Fritwell Parish Council response to:

Application Number 18/00825/HYBRID

Fritwell Parish Council supplementary comments on the above application as it relates to additional documents:

1. TN035 - Reassessment of the Impacts of Heyford Park and Associated Mitigation on Local Villages.
2. Figure 6.2b – Pedestrian and Cycle Connections.

WALKING AND CYCLING STRATEGY

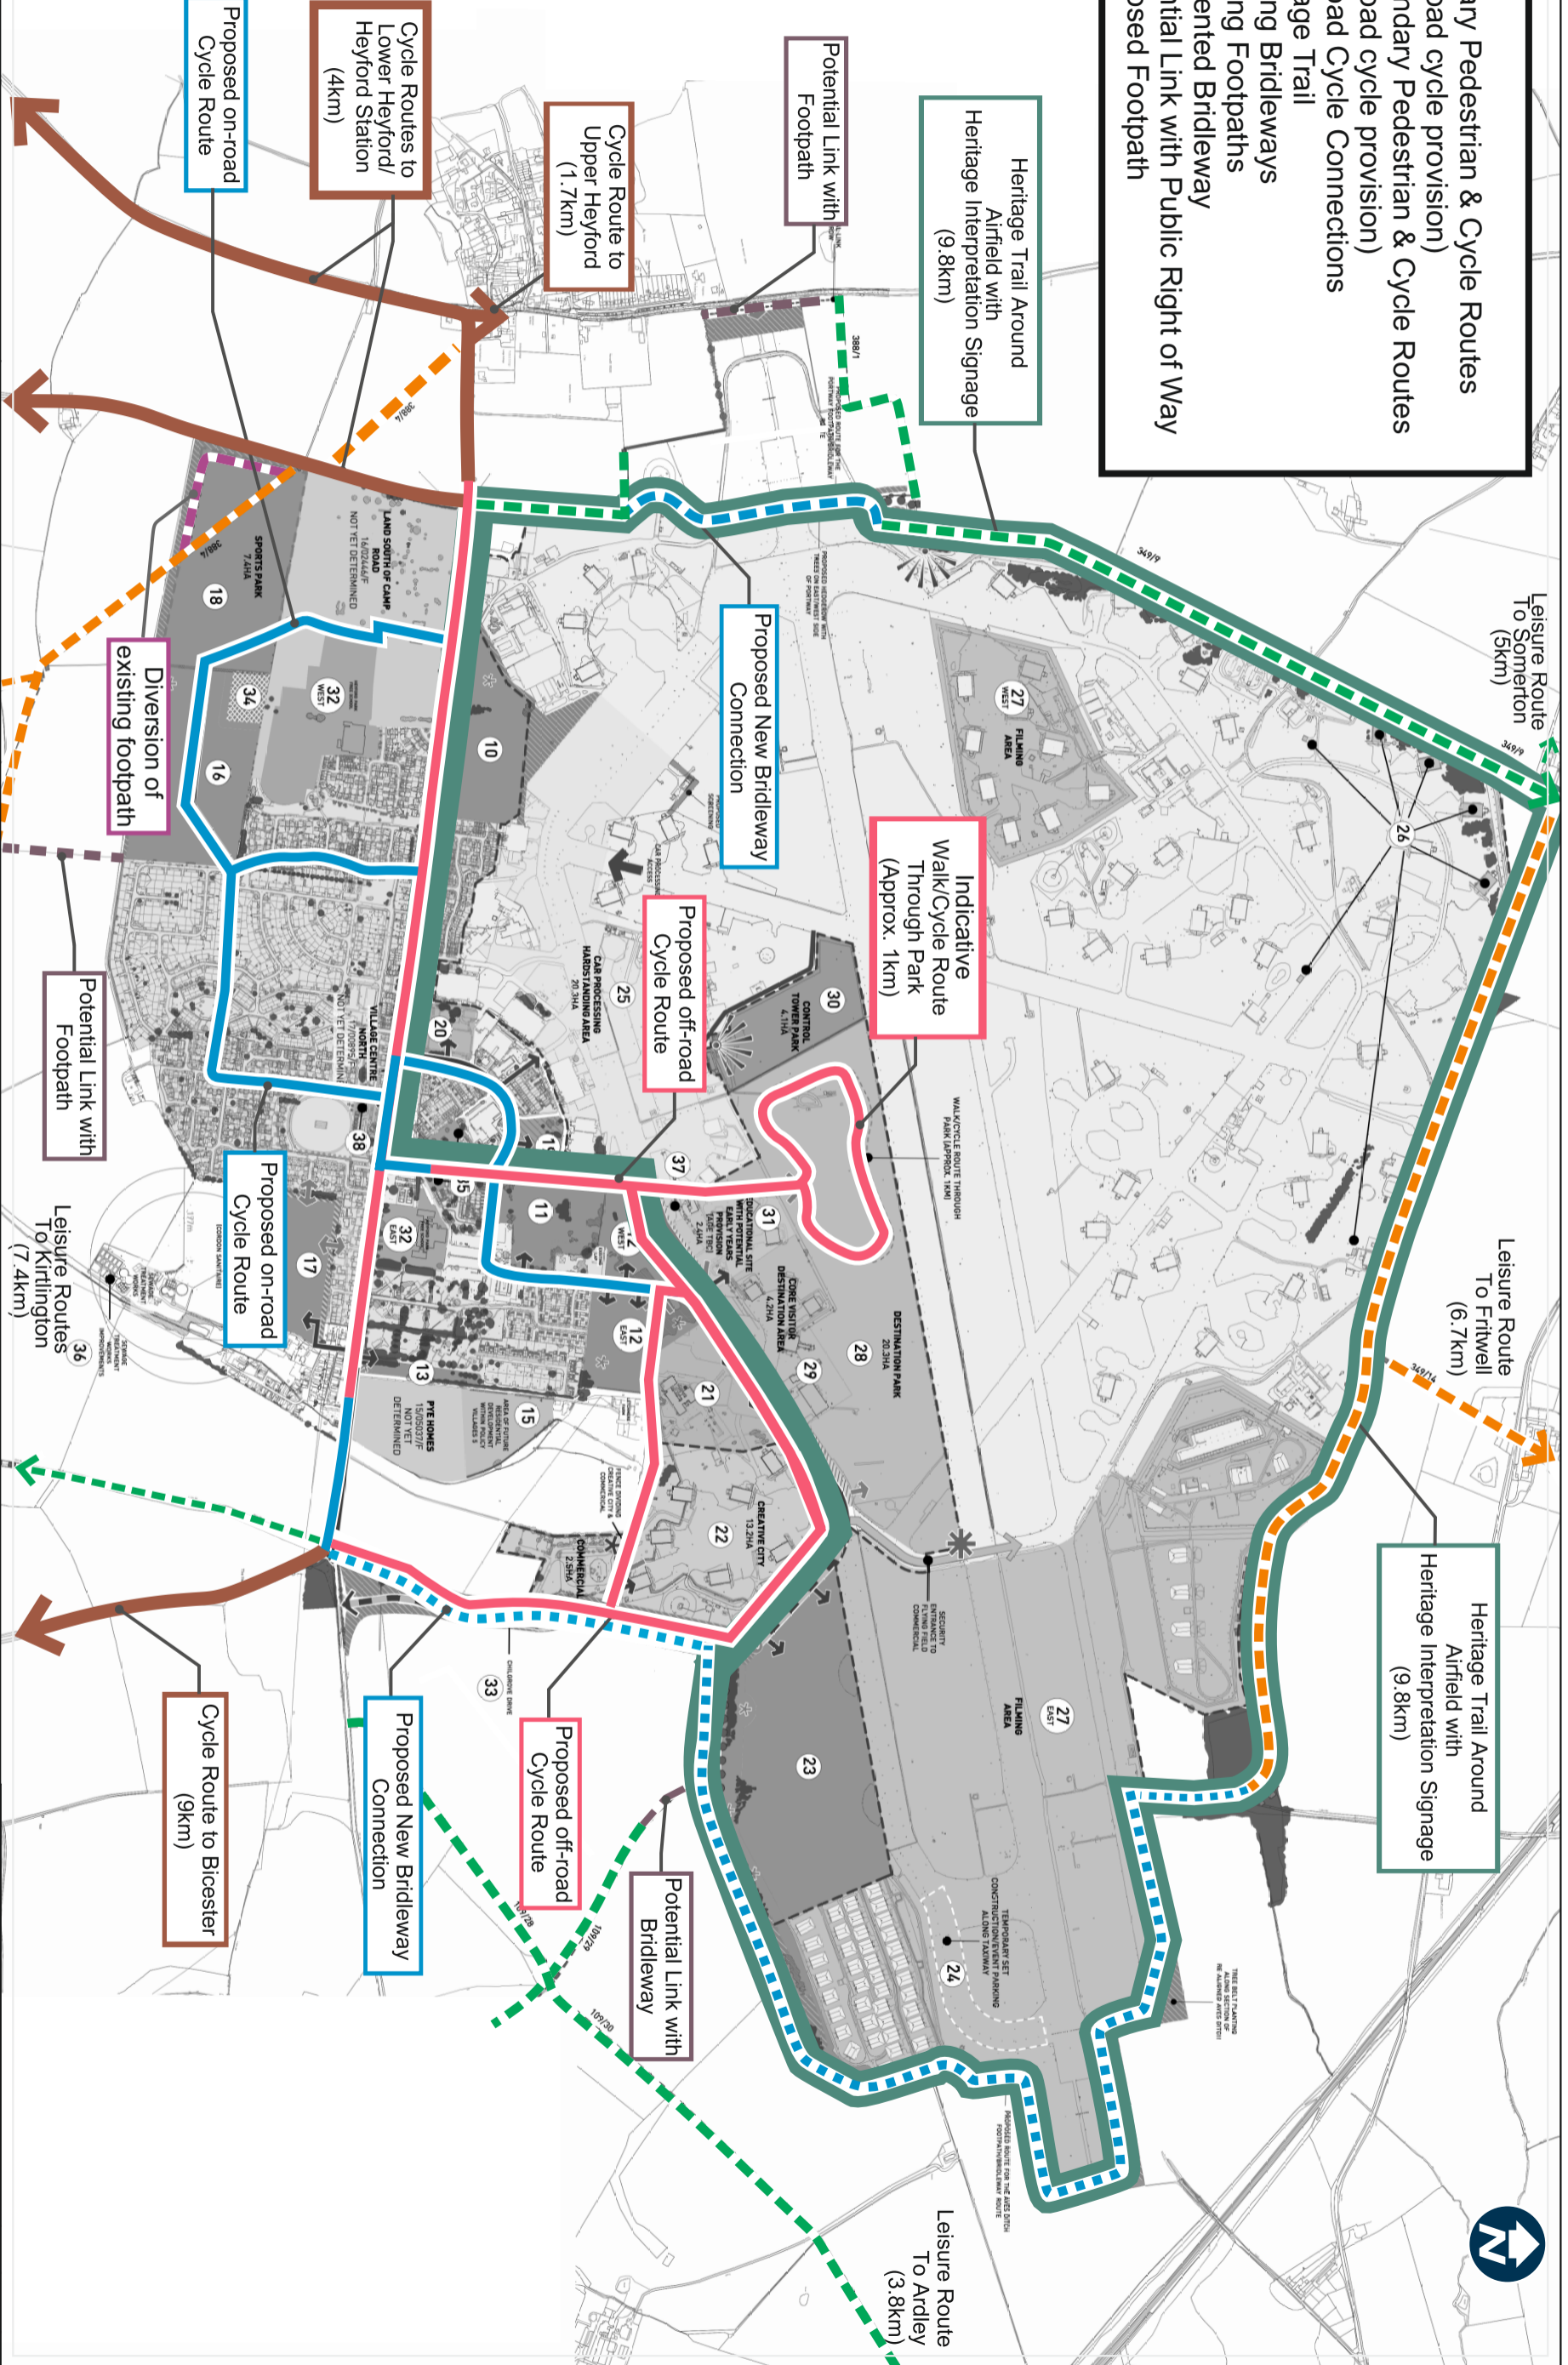
Footpaths and Cycleways - Figure 6.2b Pedestrian and Cycle Connections and Composite Perimeter Plan

- Many walkers from Fritwell currently use Raghouse Lane up to the perimeter fence of the airbase and the linked footpath 349/13 to the west. Currently this footpath leads along the margins of fields; a rural walk with woodland and bushes between the footpath and the security fence for the airfield.

- Fig.6.2b suggests that this footpath is incorporated into the Heritage Trail along the edge of the airfield. We have been unable to find details of the exact nature of the Heritage Trail; whether it is fenced in any way and fully accessible along the northern edge of the site. The Parish Council is concerned that as part of the Heritage Trail, the current rural footpath will not be freely accessible from (the continuation of) Raghouse Lane. It is hoped that plans do not include any fencing or hard surfacing of the footpath or removal of woodland and natural areas. We would like to see rural paths staying “rural”, in keeping with the surrounding countryside.

- The Parish Council welcomes the proposed Aves Ditch path to the East of the airfield shown on the Perimeter Plan, and the 2 potential links marked on Fig.6.2b. However, we would ask that a link from the Raghouse Lane path should be available, increasing connectivity and enabling Fritwell walkers to more easily use this route to reach the new settlement at Heyford Park.
